Your ref: SSD 5175 MOD 1  
Our ref: MC-12-1769

26 October 2015

**Section 96(2) modification request to amend the concept approval and stage 1 subdivision and early works for the Eastern Creek Business Hub**

## Issues for consideration – SSD 5175 MOD 1 for the ‘Eastern Creek Business Hub’

TYPICAL CHANNEL 01 SECTION
SCALE 1:20

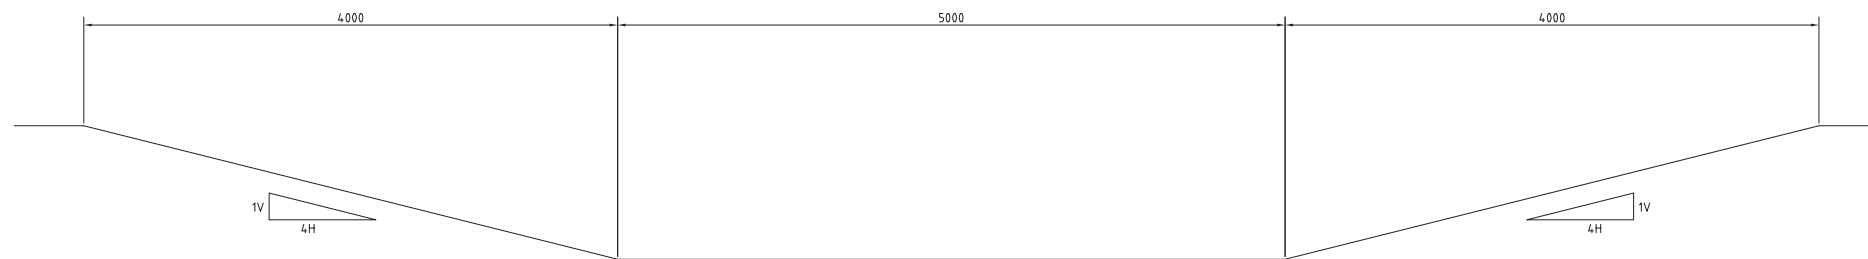
The batter slopes shown on the typical channel section do not comply with

Council's standard for maintenance. If Council is to maintain this infrastructure, then all batters should be redesigned to suit Council's requirements. It is recognised that this may necessitate a greater land take. If the channel is to remain in private ownership then appropriate easements will be required to allow the overland flow of stormwater from public infrastructure and should be conditioned accordingly.

- i. The channel conveying the upstream 100 year flows is to be designed with a Mannings n of 0.07 along the base of the channel and n = 0.1 along the sides and designed with a meandering low flow base. The slope is not to exceed 0.9%.

RETAINING WALL PLAN  
SCALE 1:1000

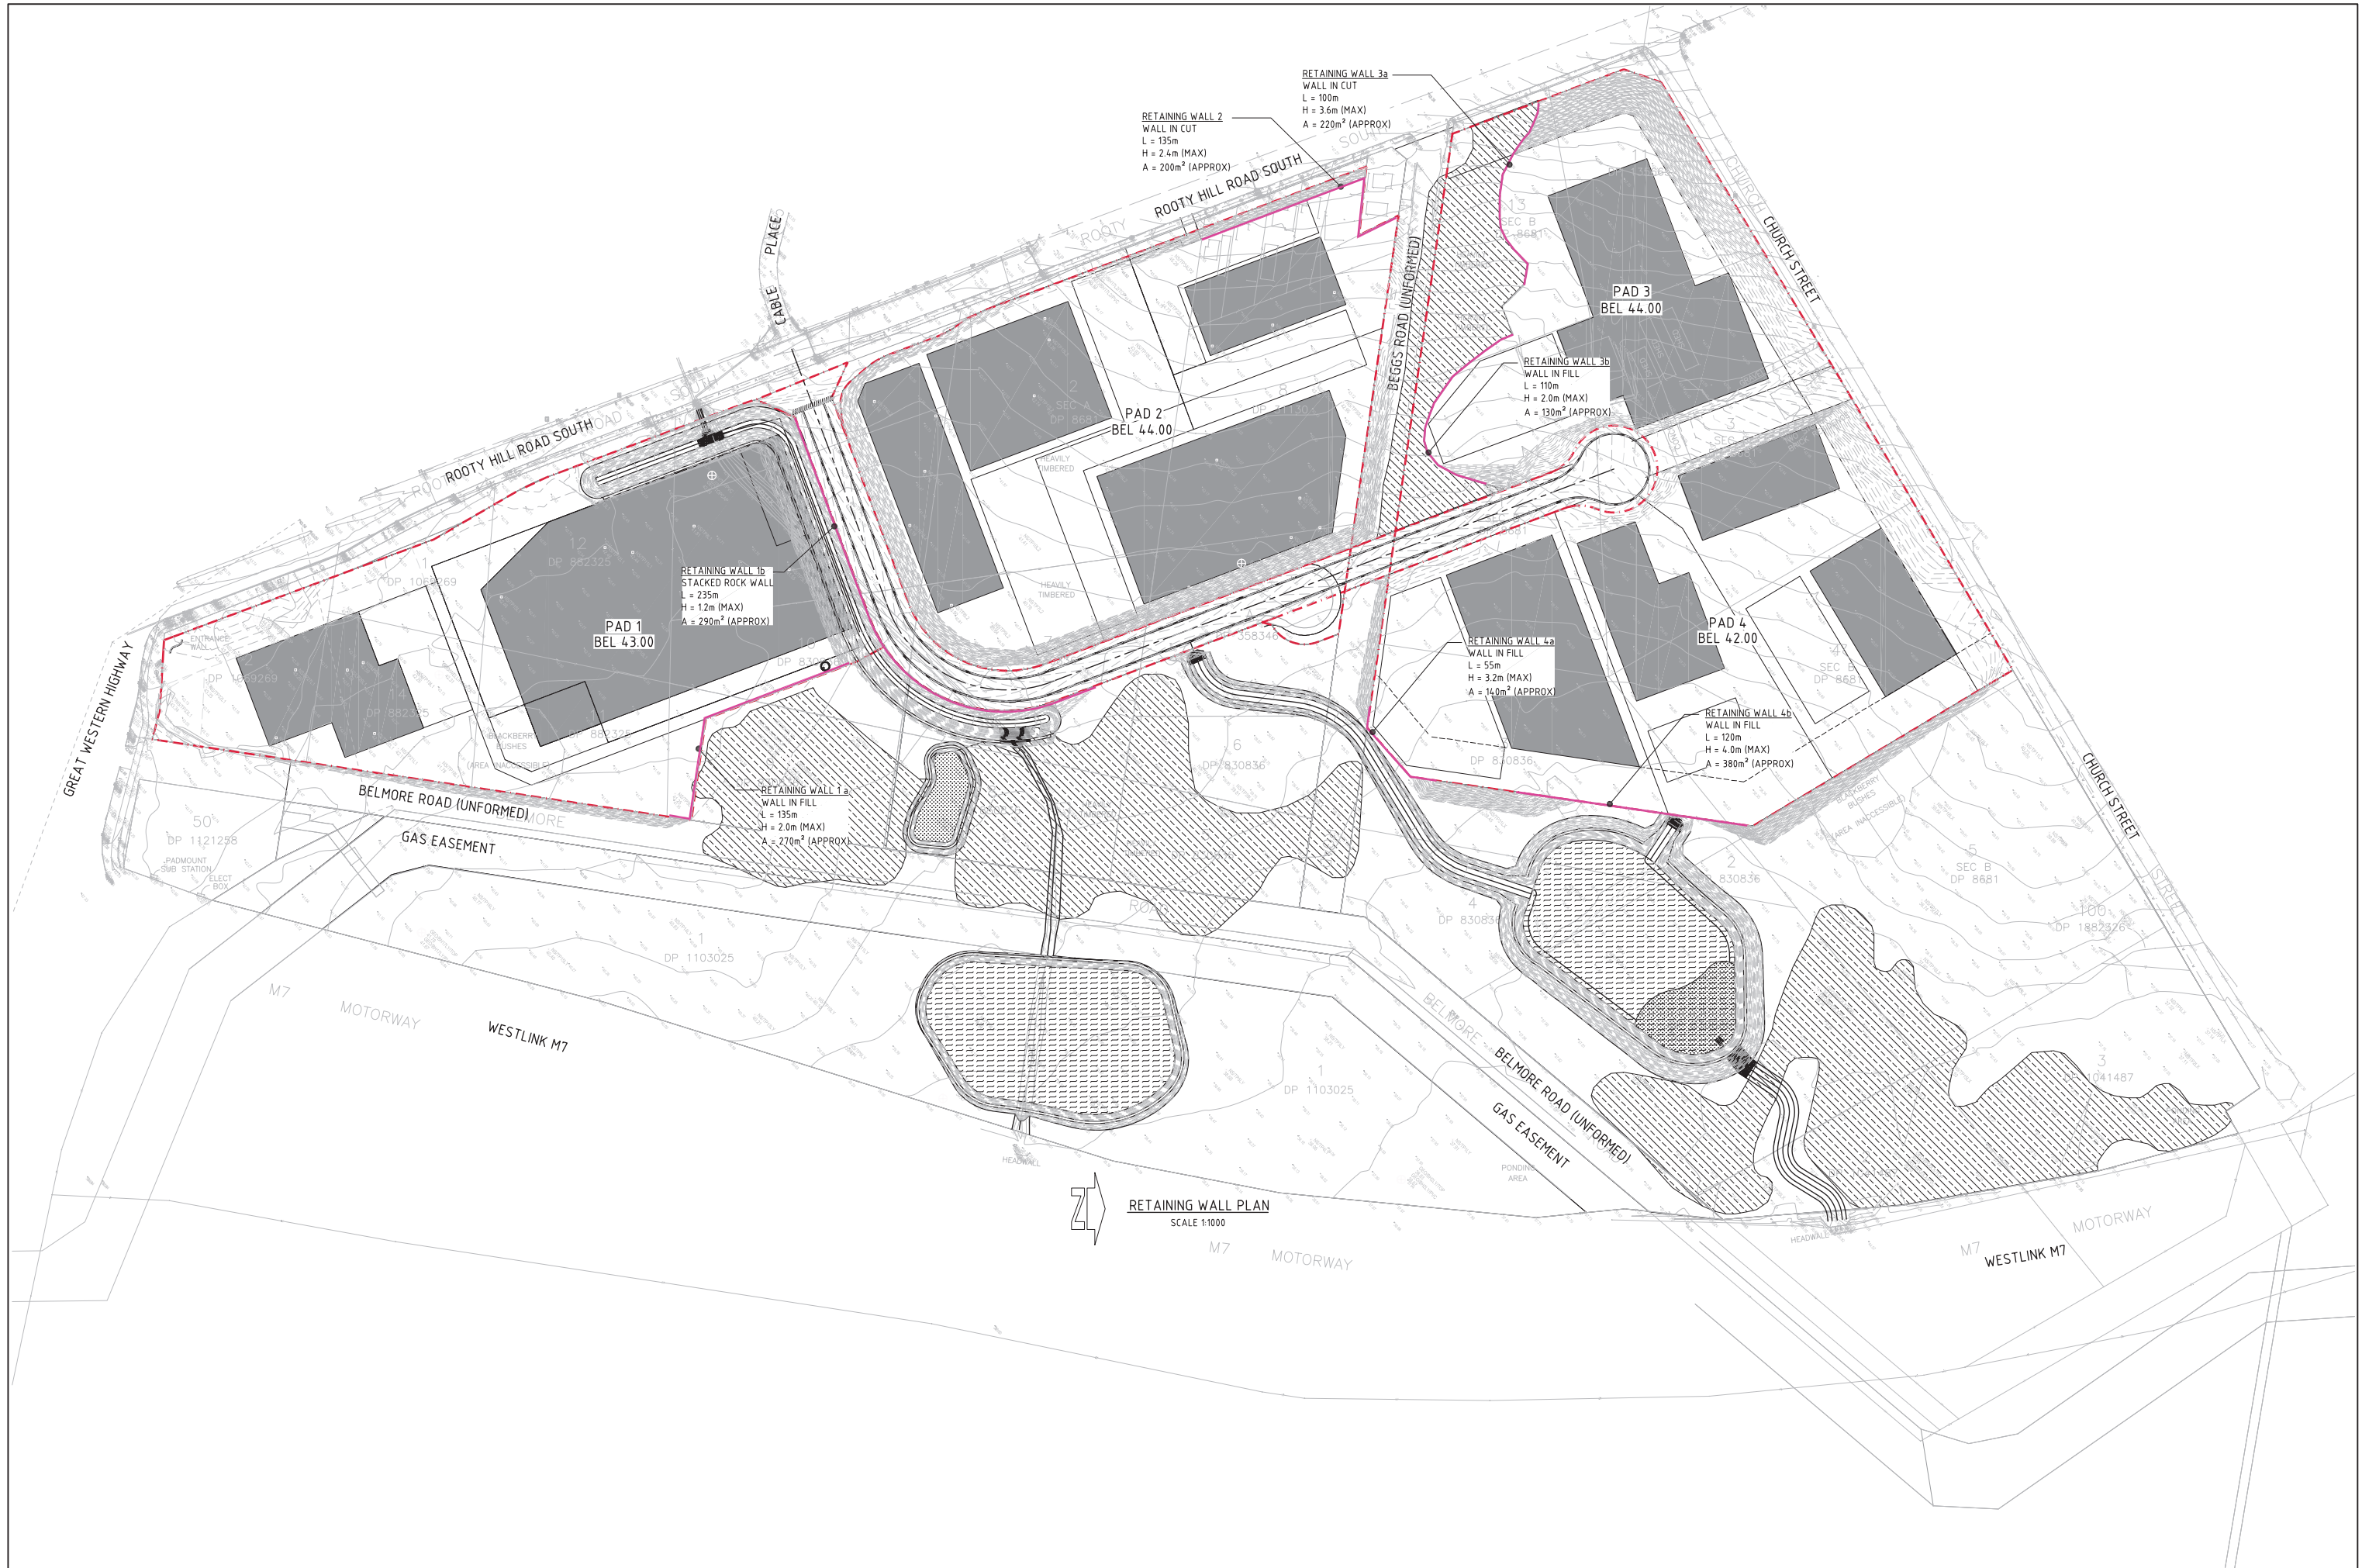
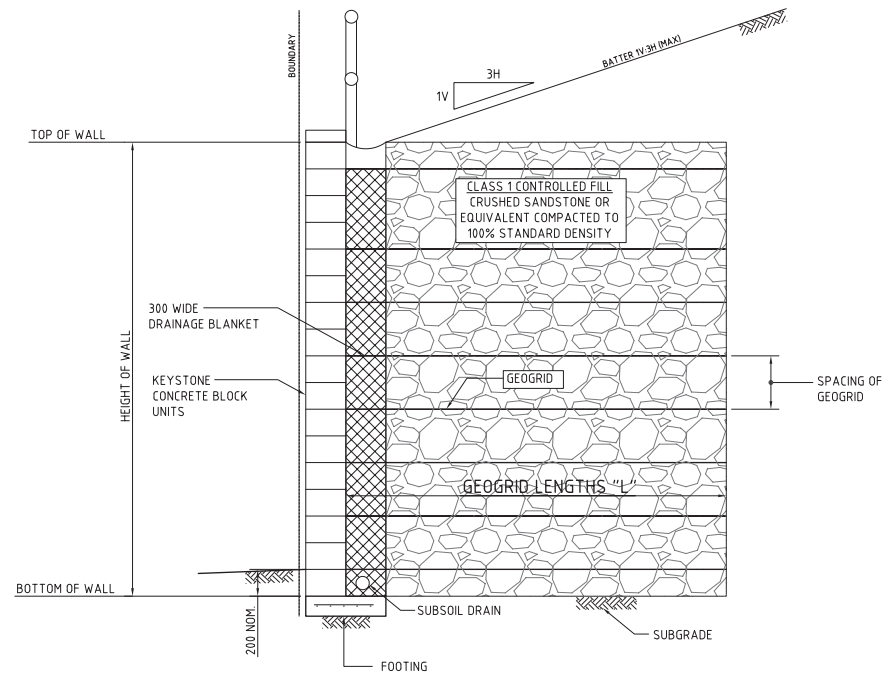
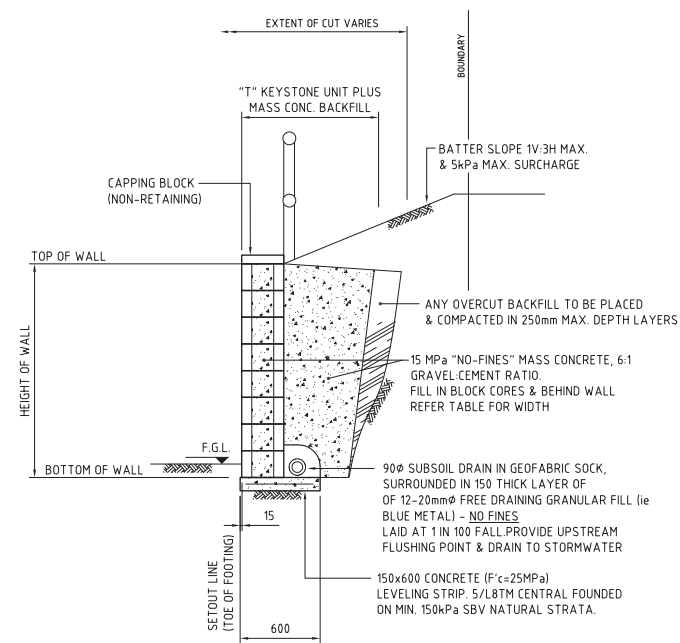
- i. PAD 2 may have a significant impact on the Beggs Road pedestrian link alignment and the remaining cottage located adjacent to the remnant bushland in the centre of the site. Consideration should therefore be given to adjusting the boundary alignment of the 1.5m – 3m high retaining wall, in the north west corner of PAD 2, so that a better transition is provided adjacent to the remnant bushland.

- B30. Details of any retaining walls, including height and material, to be constructed on site as part of the development are to be submitted to the Certifying Authority. Masonry retaining walls (i.e. no timber walls) are to be provided. All retaining walls shall be in maximum 2 metres high sections and stepped with 1 metre wide minimum planting bays which are to be landscaped. Where retaining walls 1.5m or greater are provided, these should not be provided in long expanses.
